Application no: **3/2024/0214**

Address: **Unit 45 Mitton Business Park Mitton Road Whalley BB7 9YE**

Proposal: **Regularisation of change of use from Class B2/B8 (general industrial) to Class E (commercial business and service), provision of mezzanine floor and extension of opening hours to 6.30am to 9.00 pm Monday to Friday, 7.00 am to 4.00 pm on Saturdays and 7.00 am to 1.00pm on Sundays.**

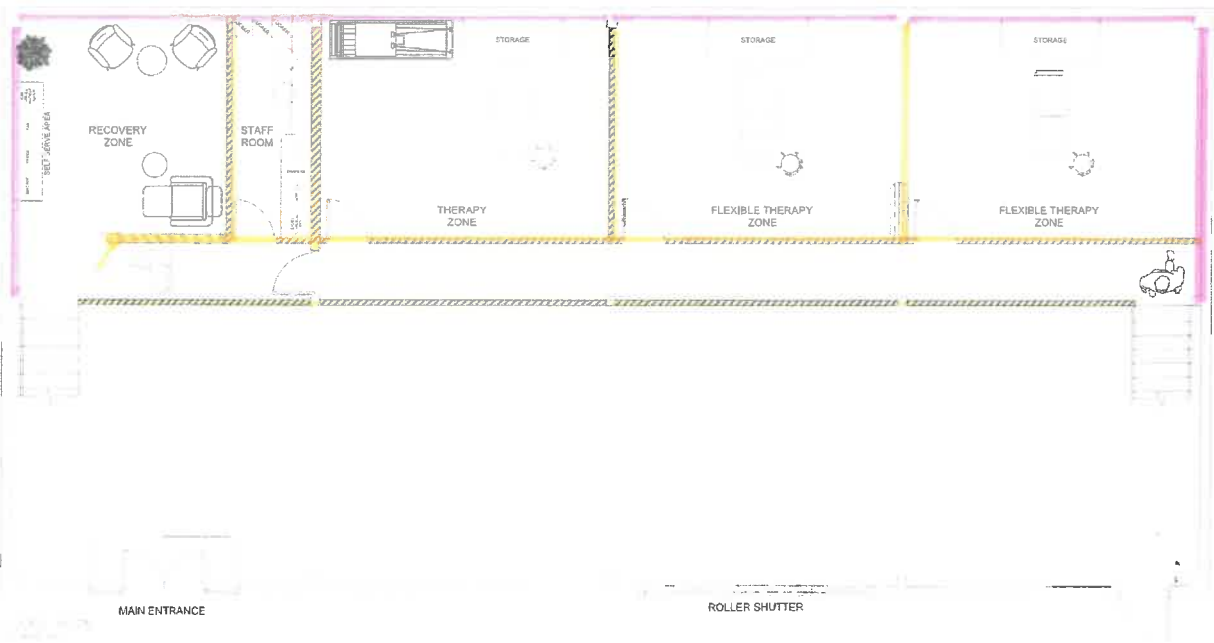
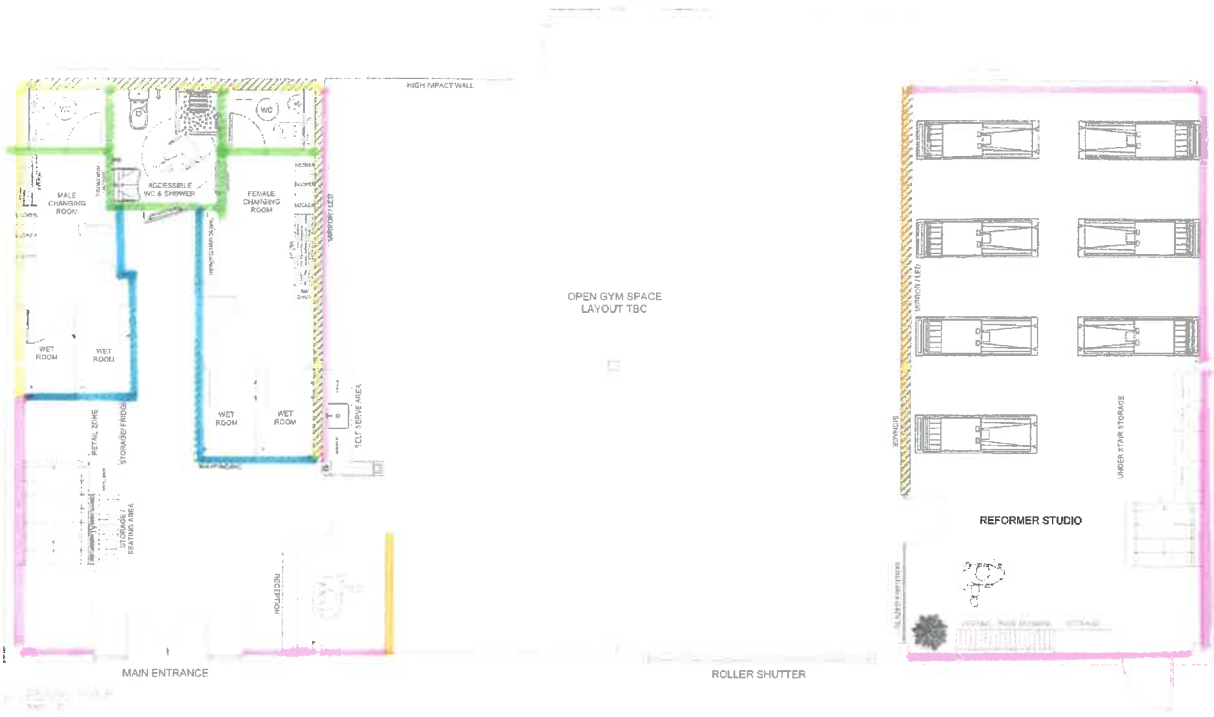
The LHA have reviewed drawing titled "Location Plan" and note that 10 car parking spaces will be provided for the Unit. To ensure that the quantity of parking is adequate for the proposed development, the LHA require the Agent to provide further details regarding the existing and proposed internal floor area of the site. This way, the LHA can assess whether the proposal complies with the LHAs parking guidance as defined within the Joint Lancashire Structure Plan, given the proposed use.
